Harnett County
420 McKinney Pkwy
LILLINGTON, NC 27546
Phone:
Fax:

SUBJECT: **SFD2204-0002**
SINGLE FAMILY DWELLING

Here are the results of all Inspections located at **291 PENDERGRAFT RD:**

FOUNDATION PLAN & STRUCTURAL DETAILS

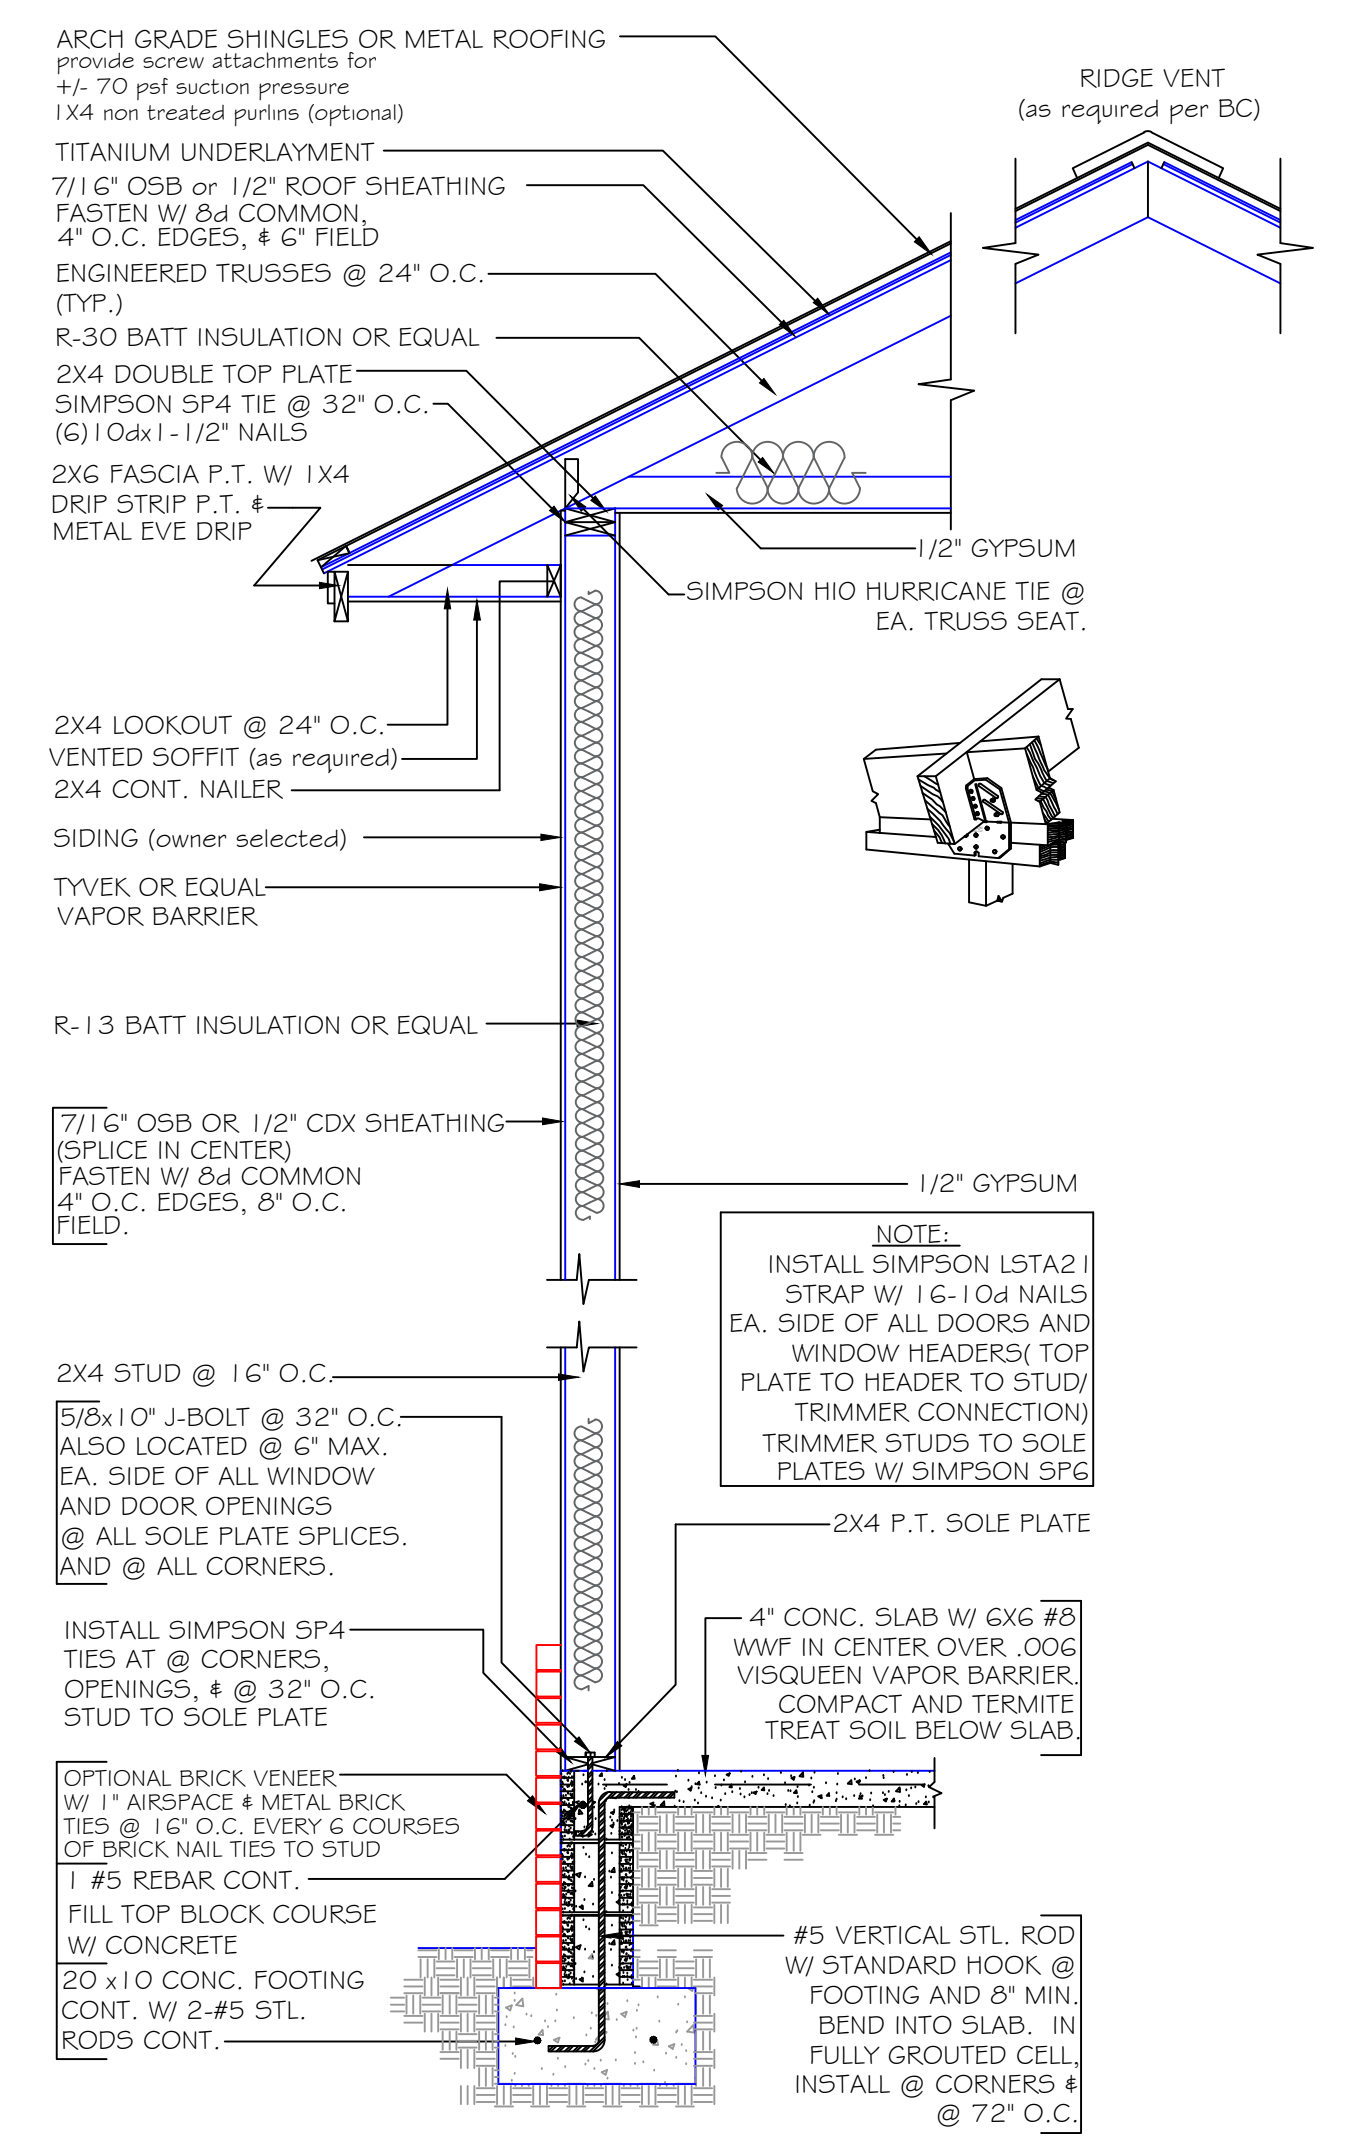
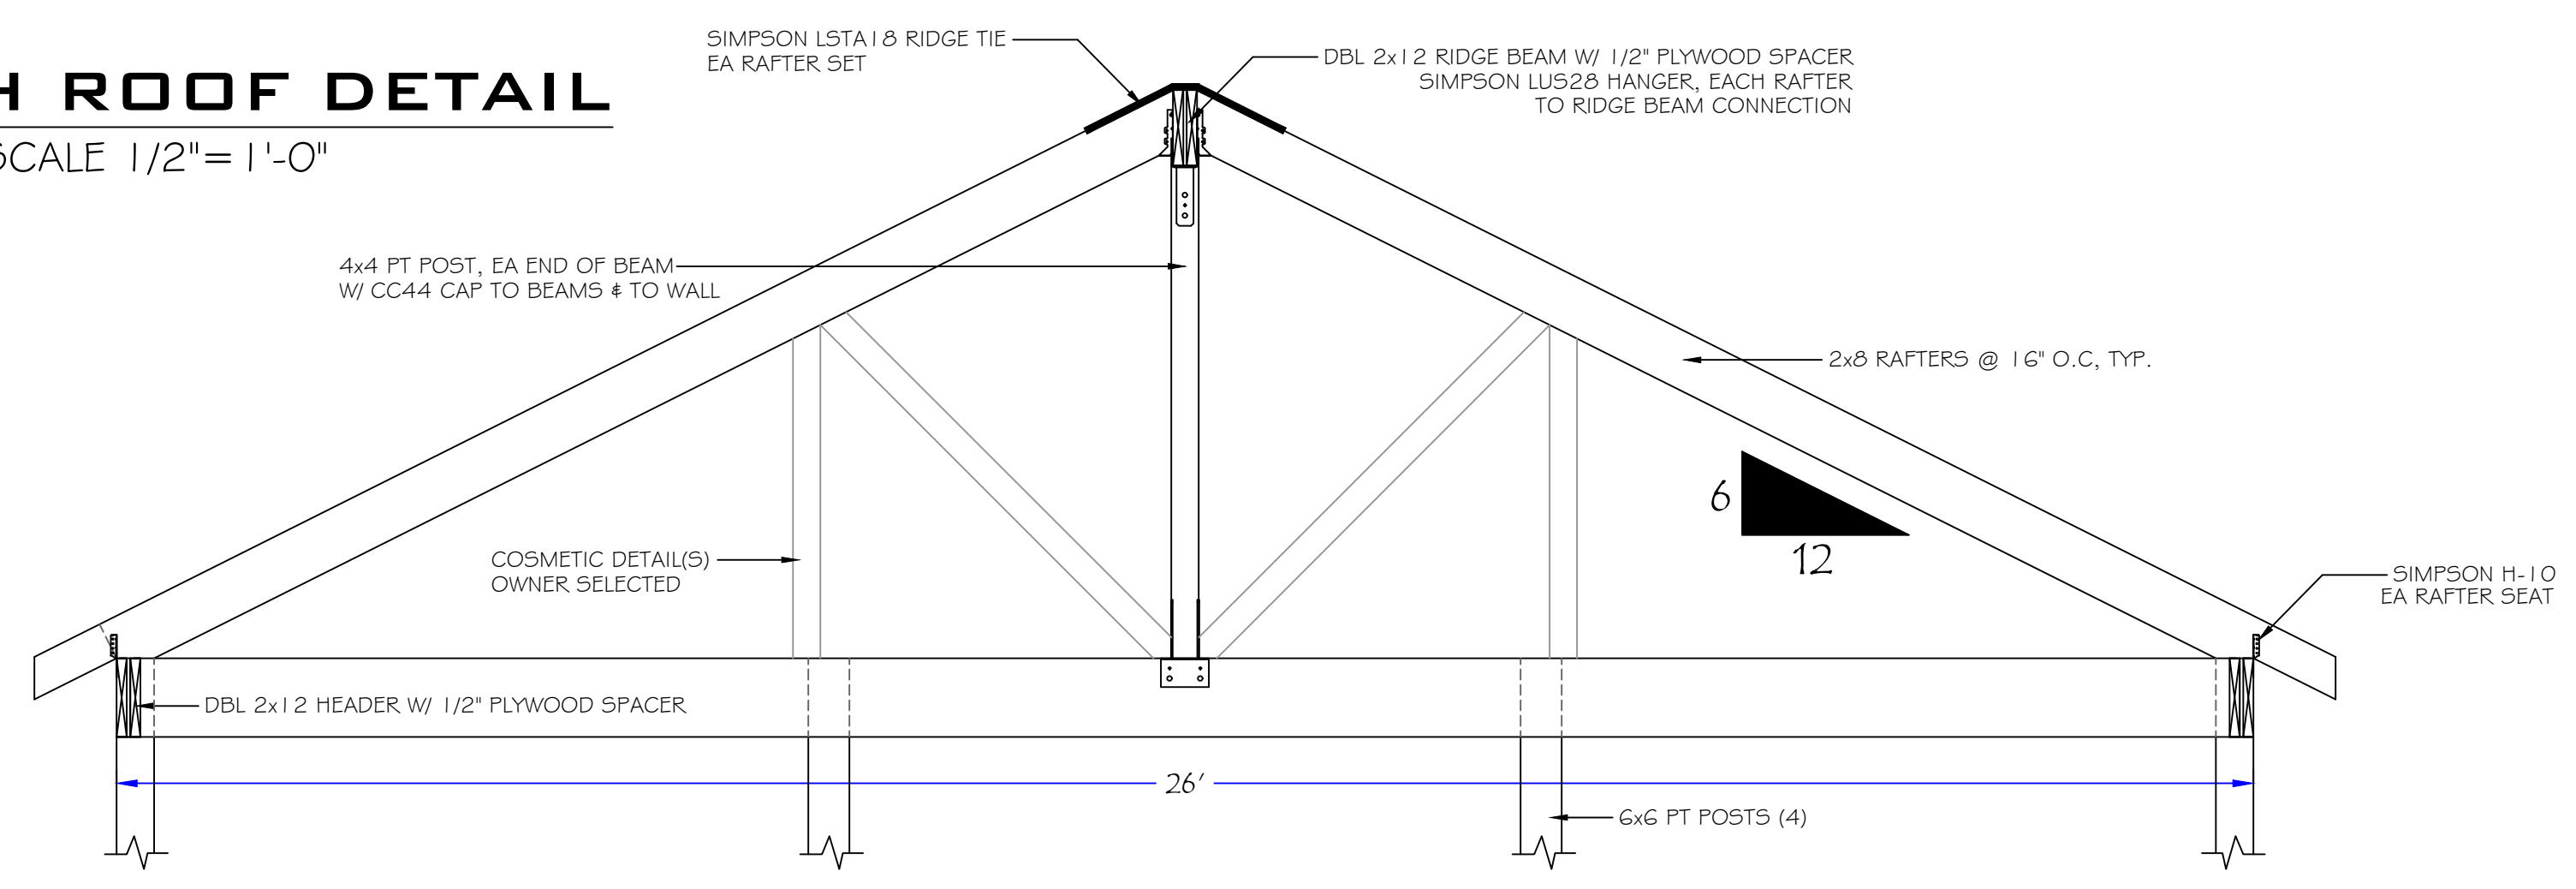
Inspection Type: FOOTING
Scheduled Date/Time: 3/31/2023
Completed Date/Time: 3/31/2023
Inspector: John B Kokoszka
Result: DISAPPROVED
Remarks:
Notes: The footing needs to be 8 inches deep. Need to have the revised set of plans uploaded or get the original from Harnett County.

Inspection Type: FOUNDATION
Scheduled Date/Time: 3/11/2024
Completed Date/Time: 3/11/2024
Inspector: James T Hall
Result: DISAPPROVED
Remarks:
Notes: 1. Anchor bolts per code. 2. Expose footings for foundation inspection. 3. Missing foundation vents
